# Rezoning Transportation Analysis

Petition Number: 2023-080

**From: Jake Carpenter, PE**  
Jacob.carpenter@charlottenc.gov  
980-221-5675

1 TYP. DRIVEWAY & SUBLOT CONFIG. DETAIL 1" = 30'

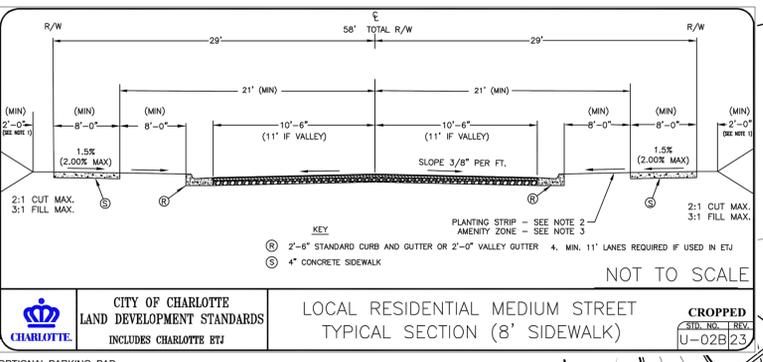
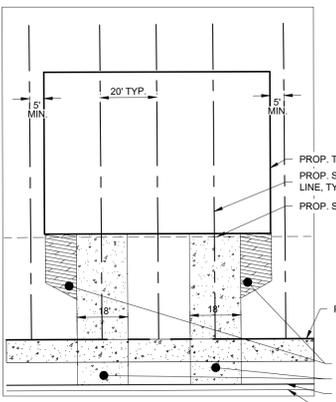
6. CDOT REQUEST: CDOT would prefer to see that the driveways were alley fed from the public street rather than direct access.

RZ-2.0

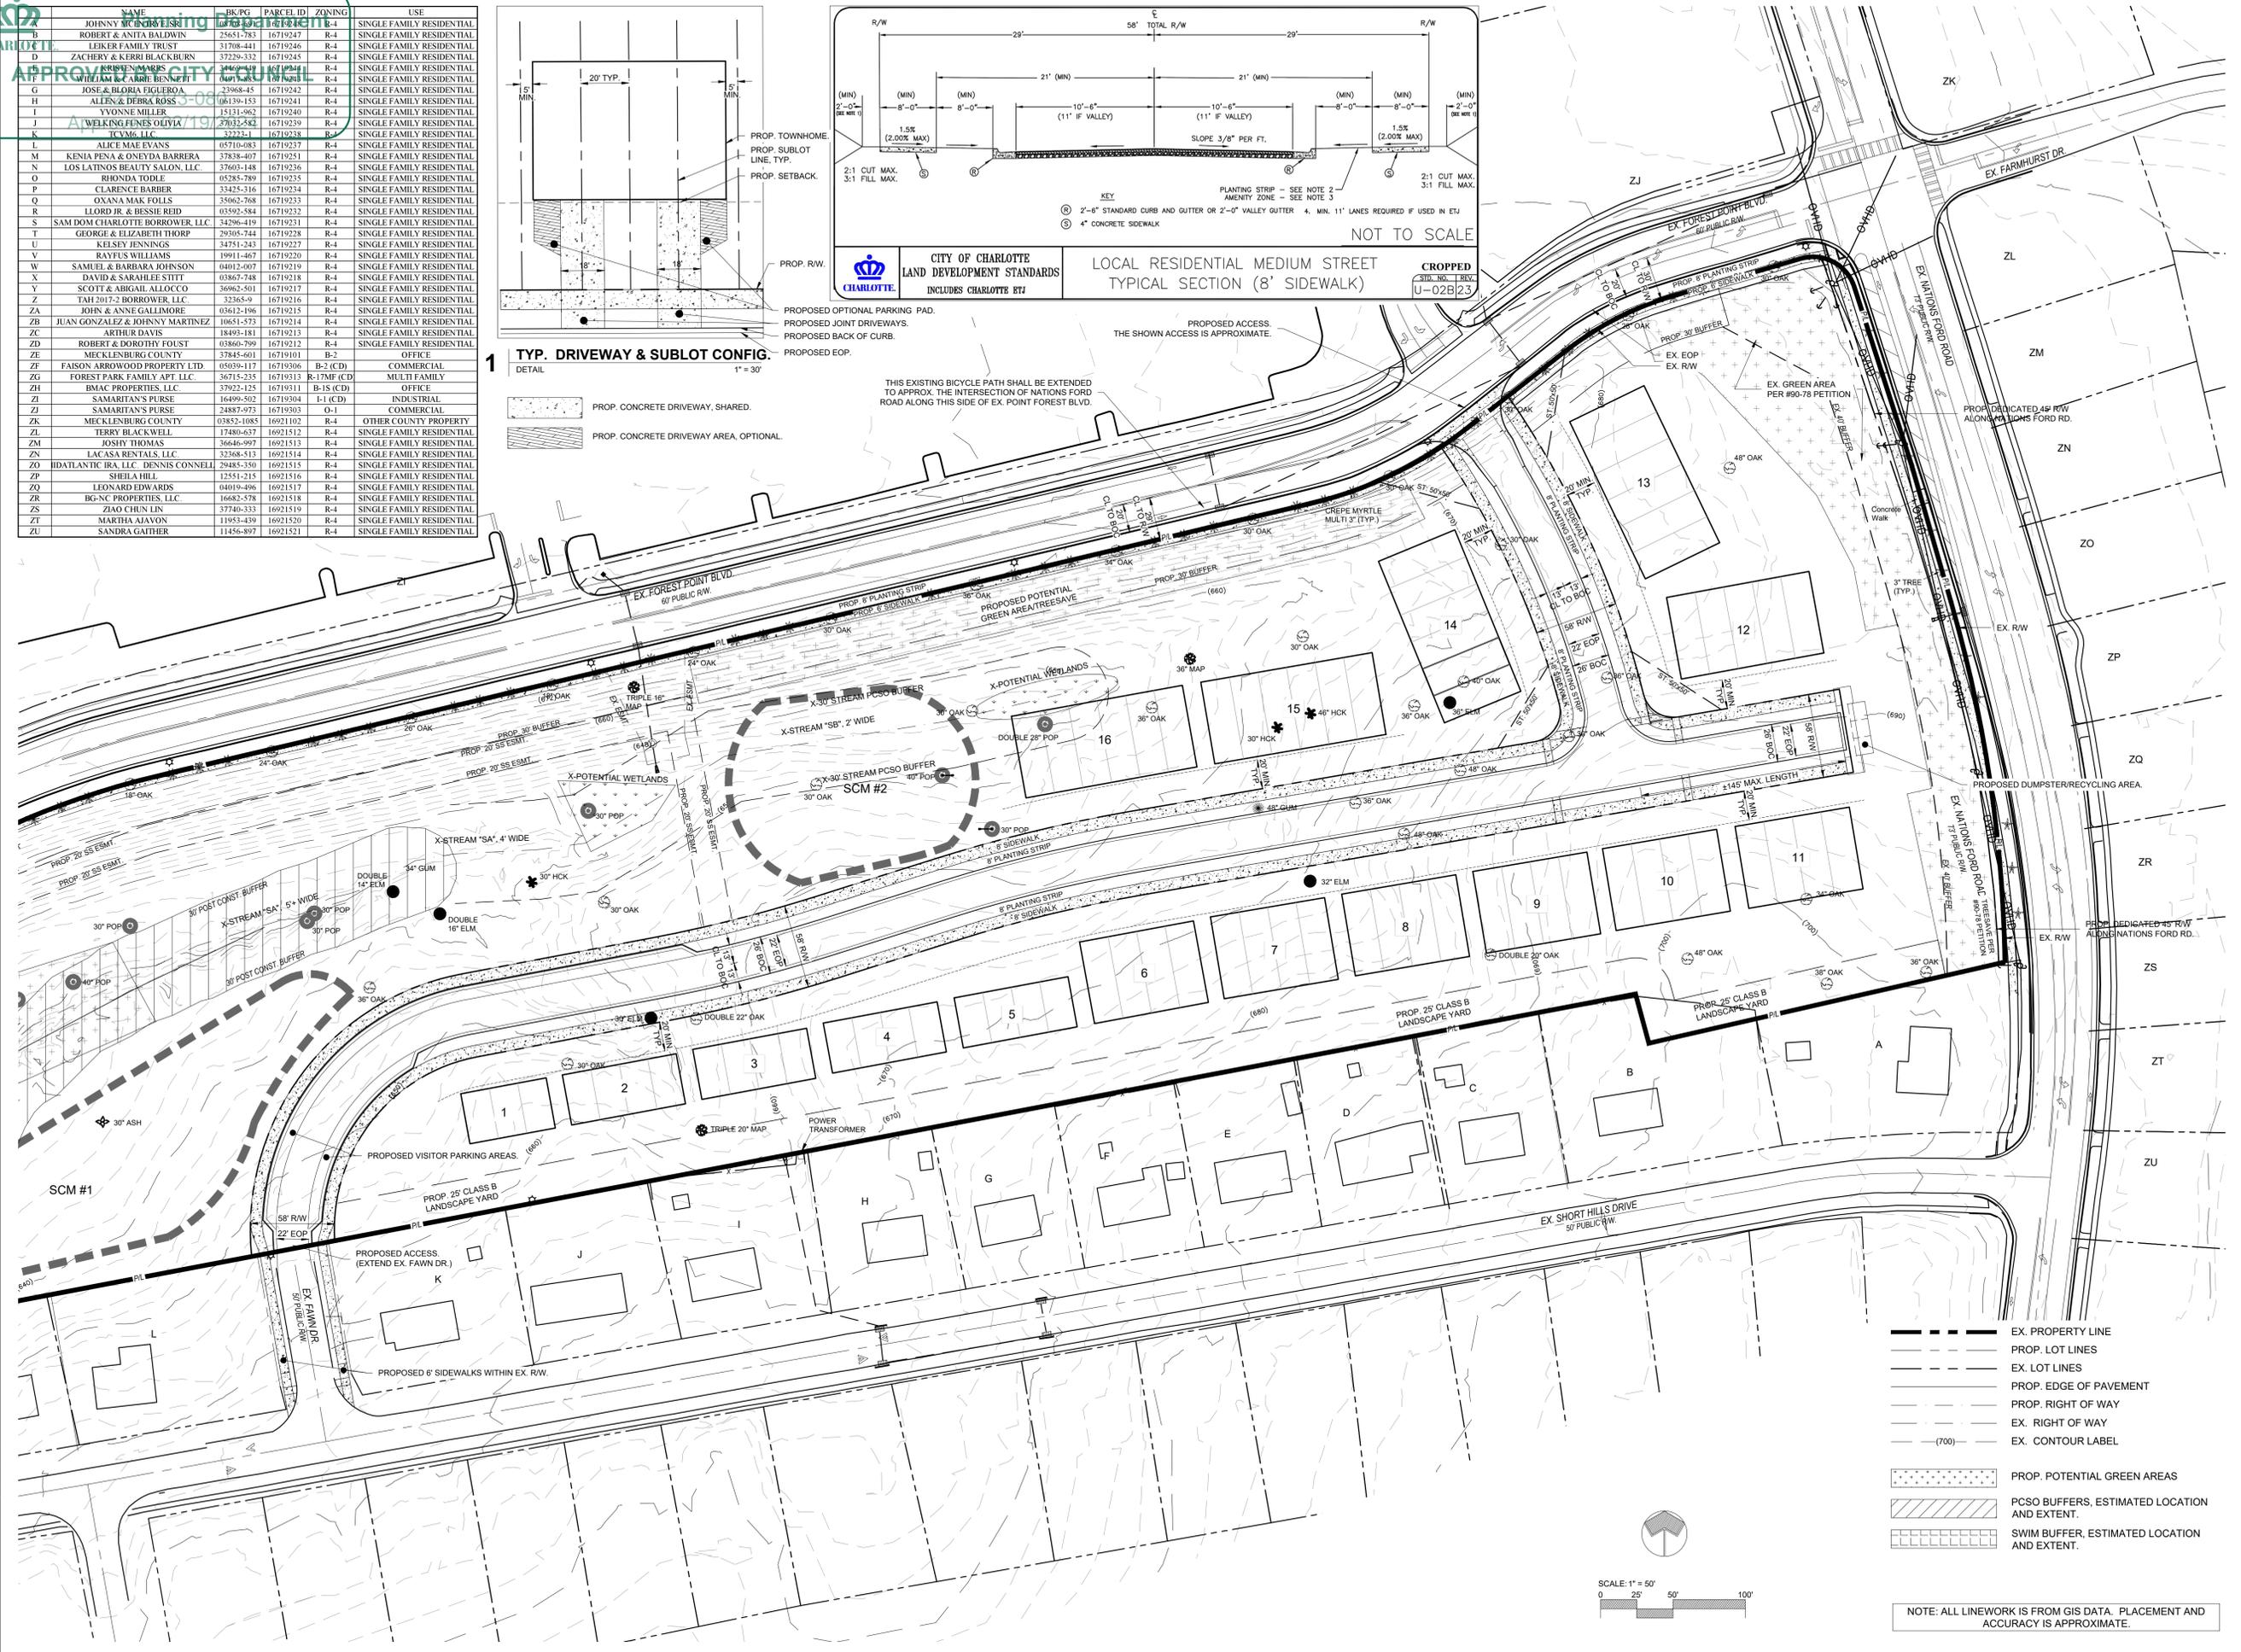
4. Revise site plan and conditional note(s) to commit to extending the bike lane on Forest Point Drive to the traffic signal at Nations Ford Road. Modify the existing curb line as needed to incorporate the bike lane.
